Permit Number: 050532

This is to certify that Worden William L /Brush & Hammer R
has permission to install 22'x22' Garage w/ roof above/ & attached mudroom
AT 127 Lester Dr 384 A027001

Dept: Zoning	Status: Approved	Reviewer: Tammy Munson	Approval Date: 05/13/2005
Note:			Ok to Issue: <input checked="" type="checkbox"/>
Dept: Building	Status: Approved with Conditions	Reviewer: Tammy Munson	Approval Date: 05/13/2005
Note:			Ok to Issue: <input type="checkbox"/>

FRONT ELEVATION
1/8" = 1'-0"

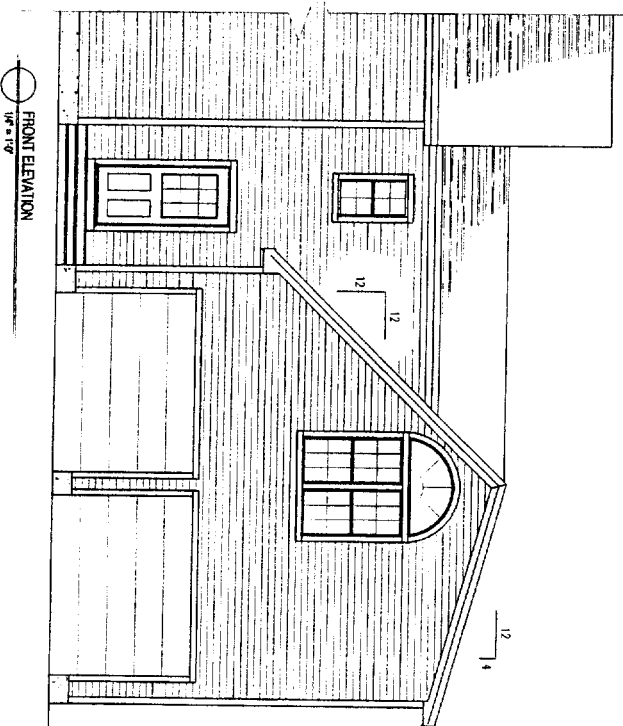
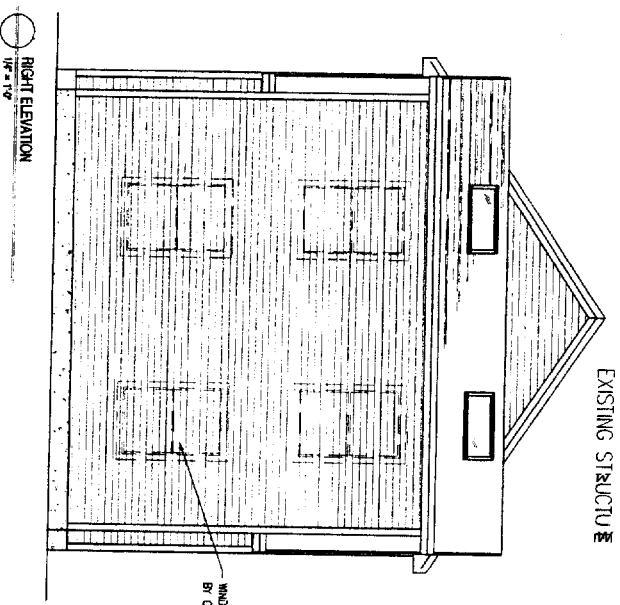
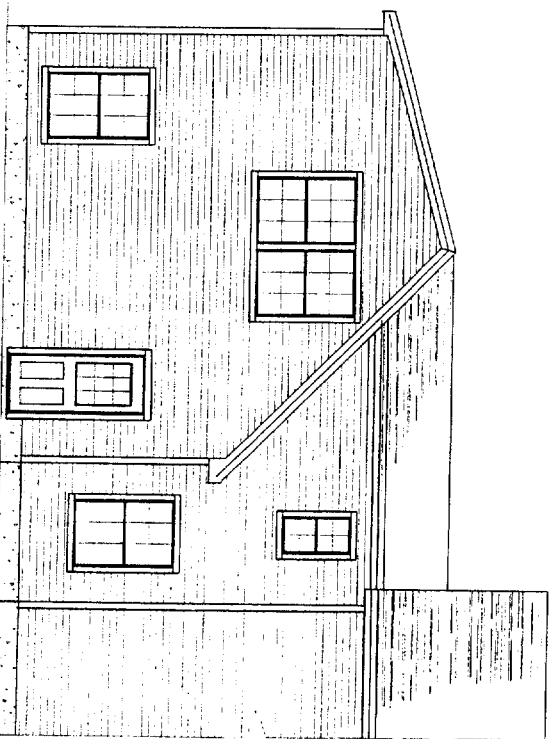
Comments:
5/12/05-tmm: need header schedule, fire sep. detail, stair/guard details, rafters need to be 2x12's 12"oc, ventilation & access for crawl space, egress windows. - called builder

1) Permit approved based on the plans submitted and reviewed w/owner/contractor, with additional information as agreed on and as noted on plans.
